Your Ref: OWPC20251
Our Ref: FG/156/18/PL 06-08-2018
Please ask for:
Samantha Allen

Outdoor seating area on pavement consisting of 2 No. tables & 4 No. chairs to be stored when not in use.

Andalucia Restaurant 58 Ferring Street Ferring

PROJECT	RESTAURANTE ANDALUCIA 58-60 Ferring Street, Ferring BNT2 5JP		
TITLE			
PROPOSED CHANGE OF USE AND TABLES AND CHAIRS LICENSE			
DRAWN	DATE	SCALE	CHECKED
RM	August 2018	shown	
PROJECT	NUMBER		REVISION
BD 18114	09-01		-

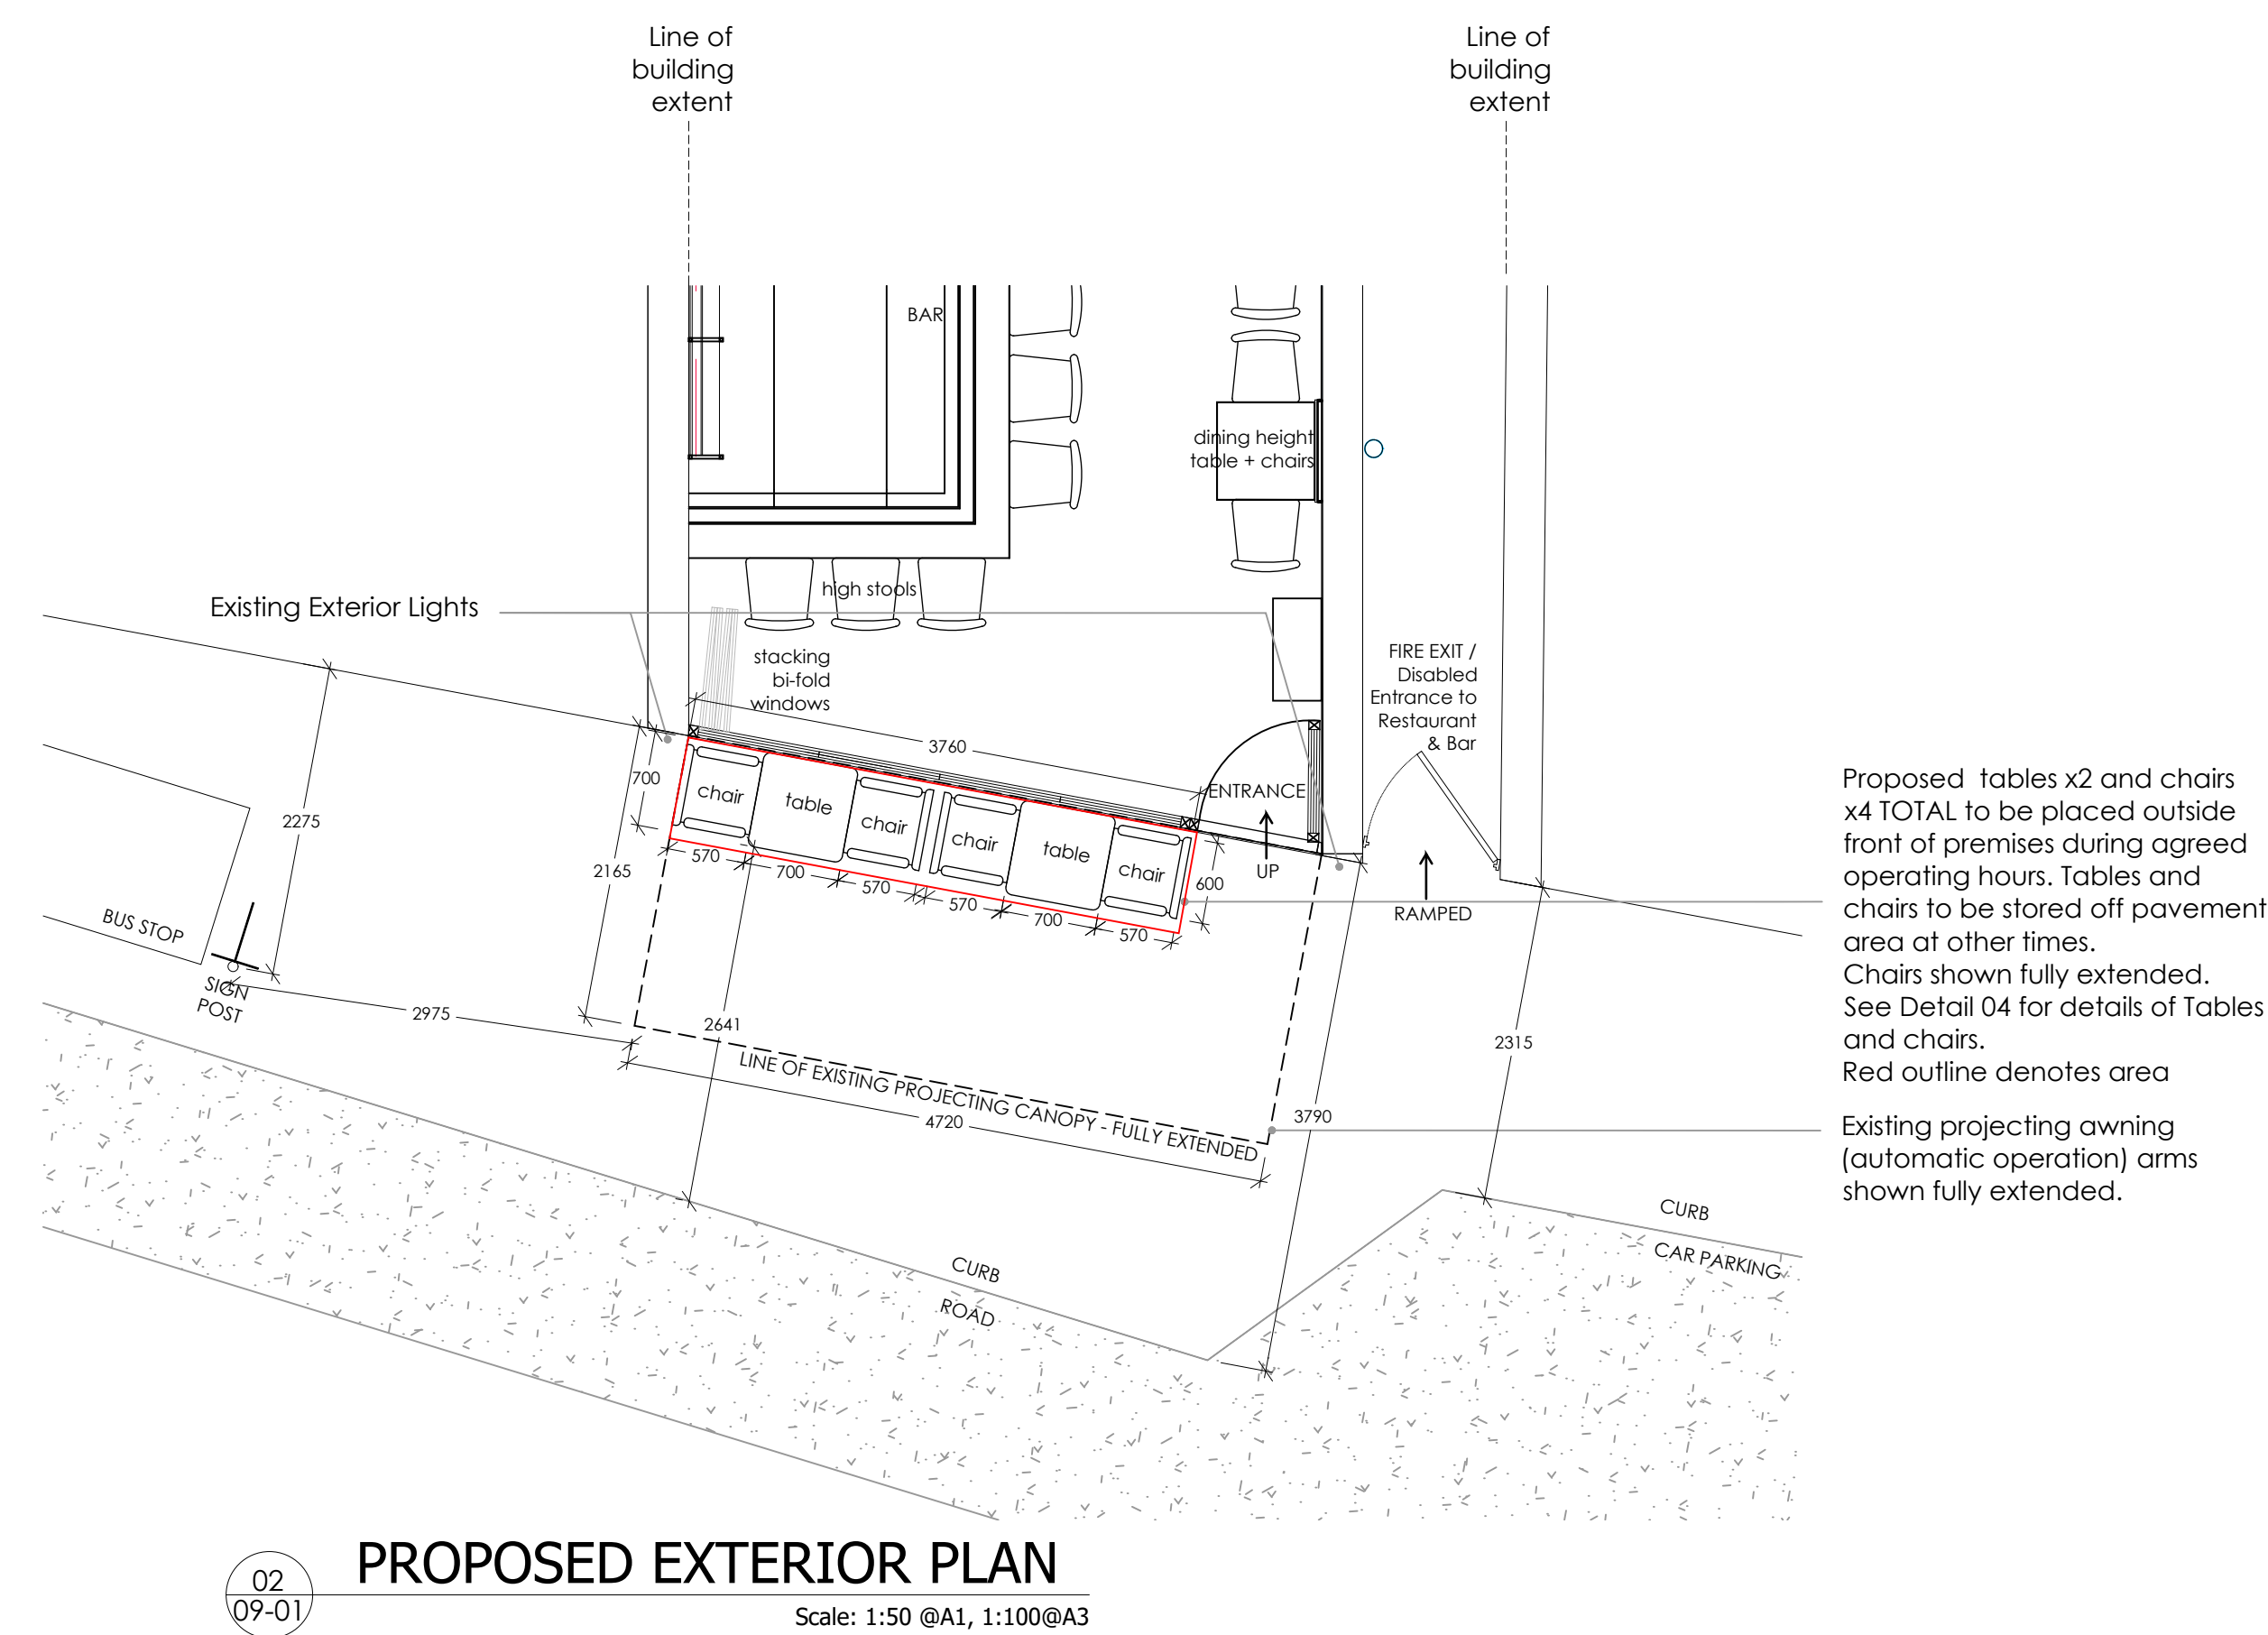
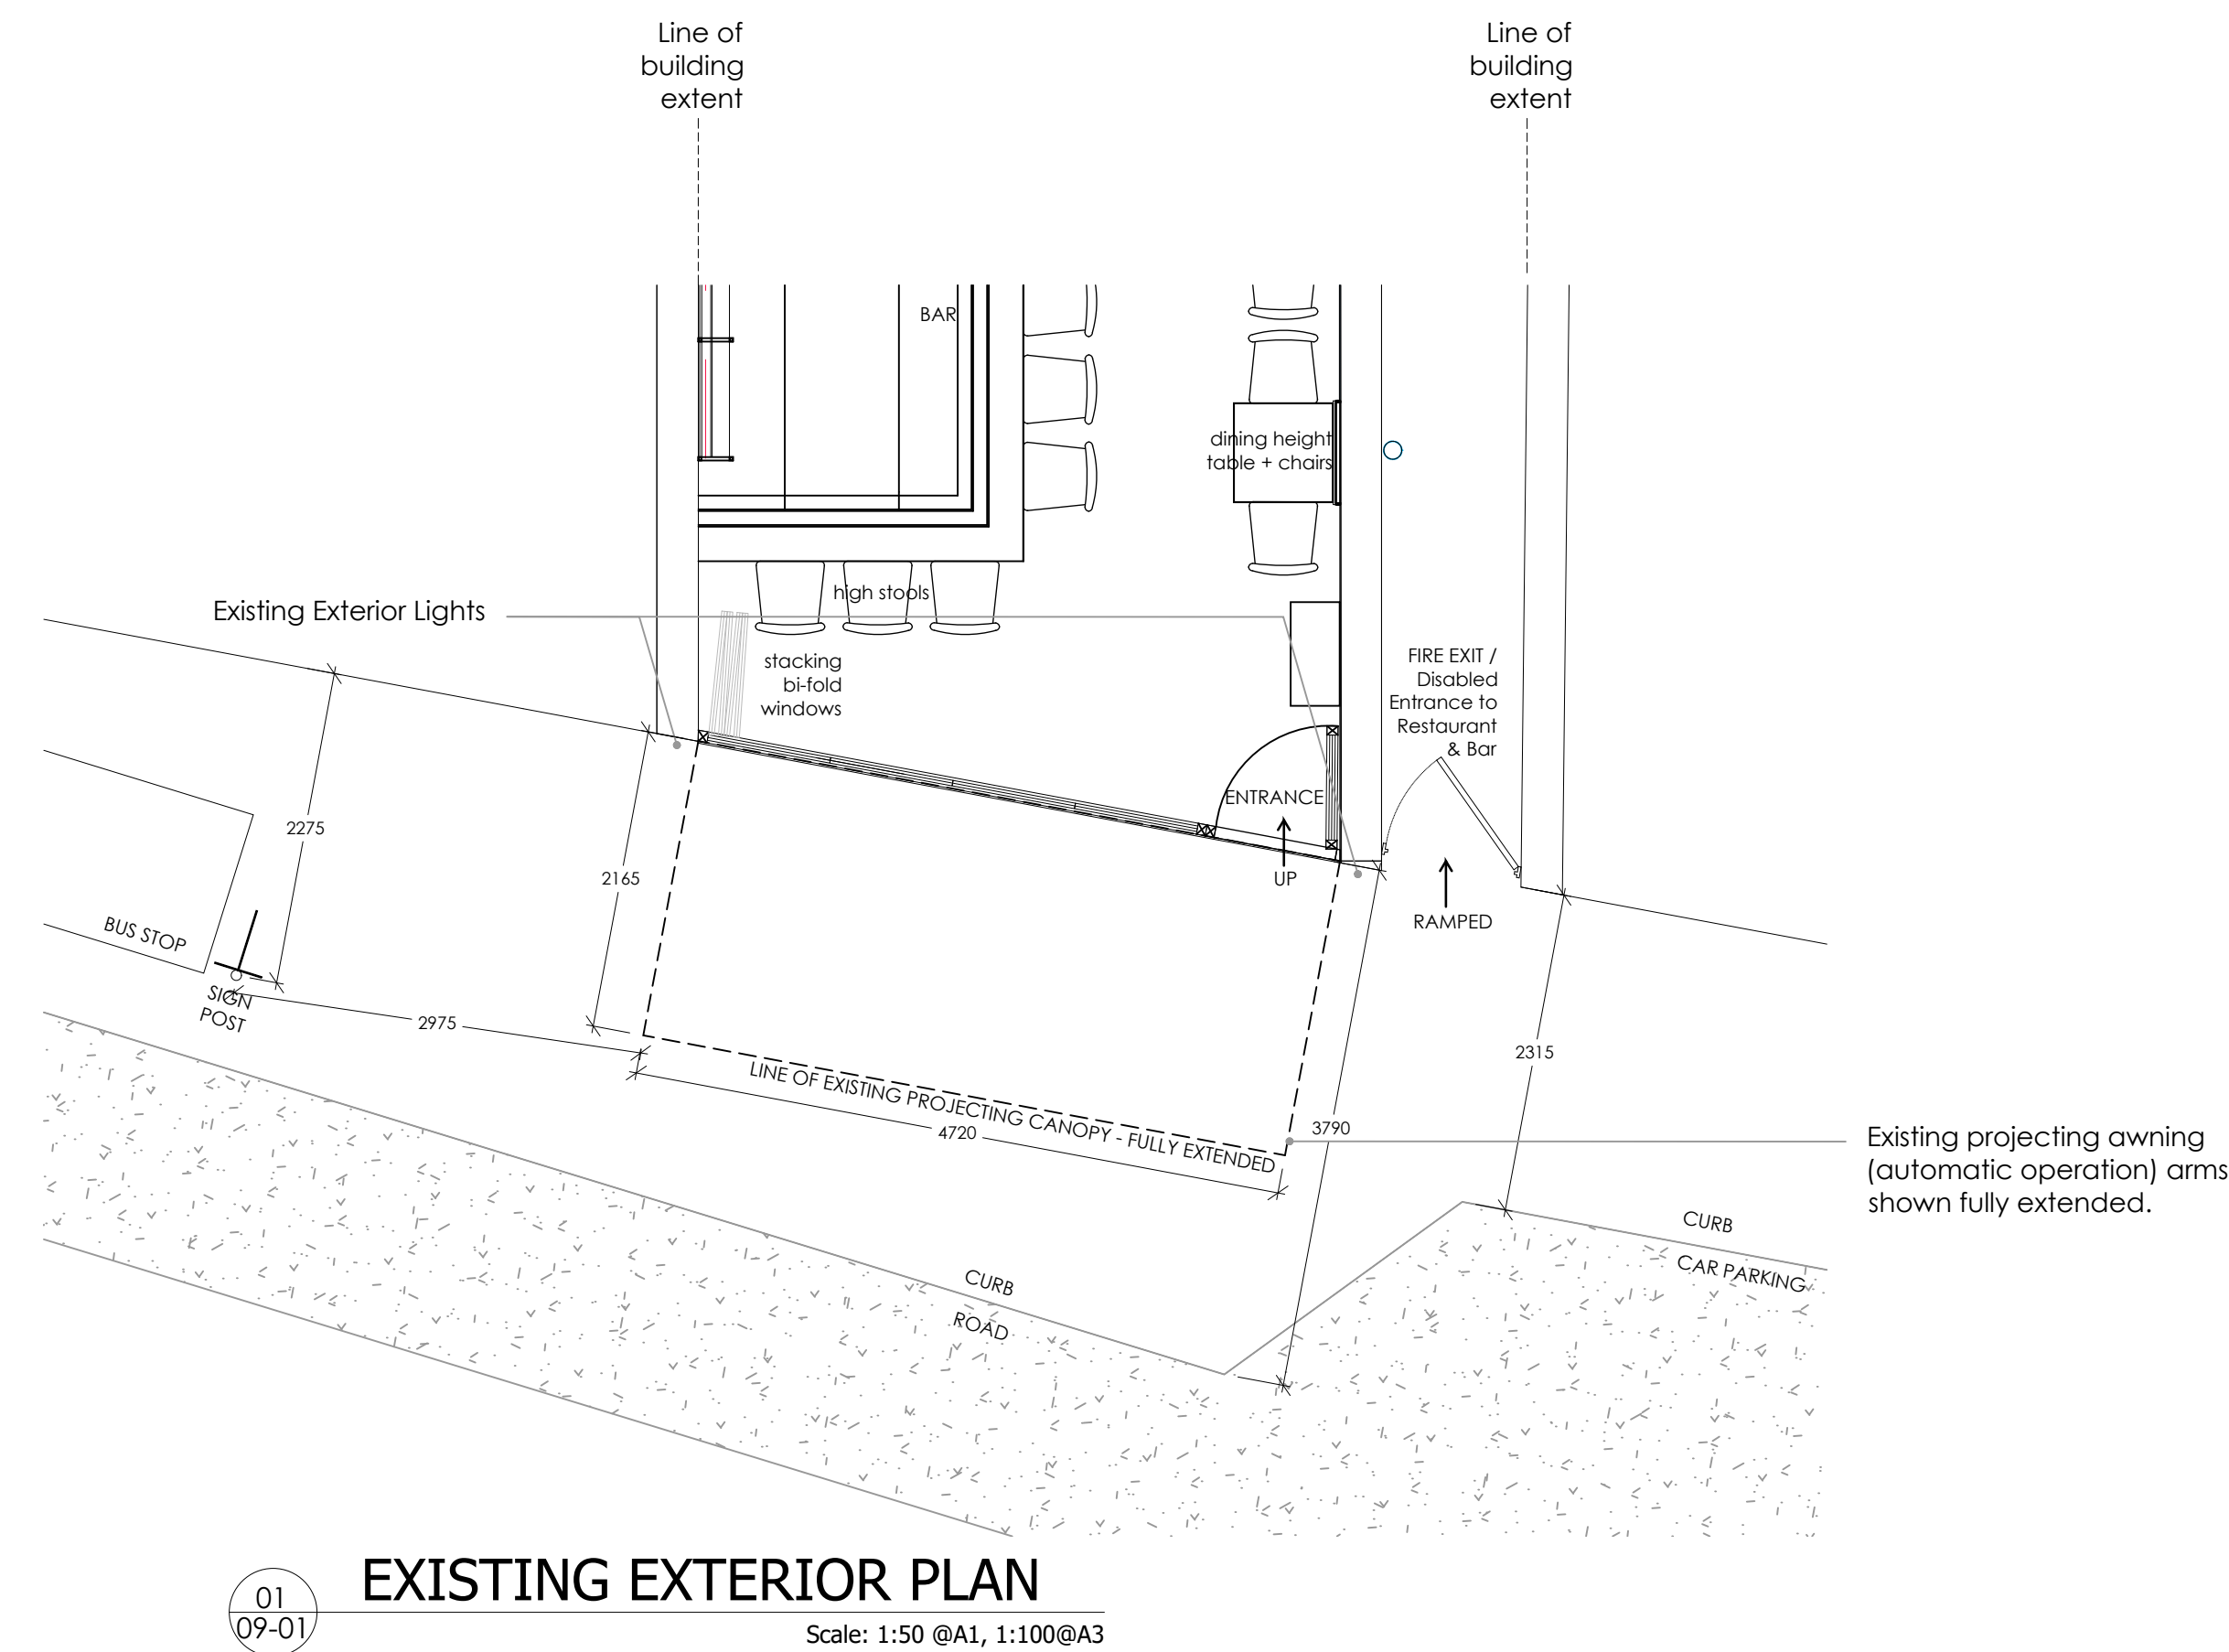
The width of pavement occupied by the tables as drawn may leave sufficient space for pedestrians as defined by regulations but when customers actually sit at the tables they will move their chairs, and probably the tables too, to make themselves comfortable and this will further reduce the width available to pedestrians and buggies.

May I suggest, again, that a WSCC officer visits the site and considers how these tables and chairs are likely to be used, rather than how they are drawn on the plan? Ed Miller (Secretary, Ferring Conservation Group)
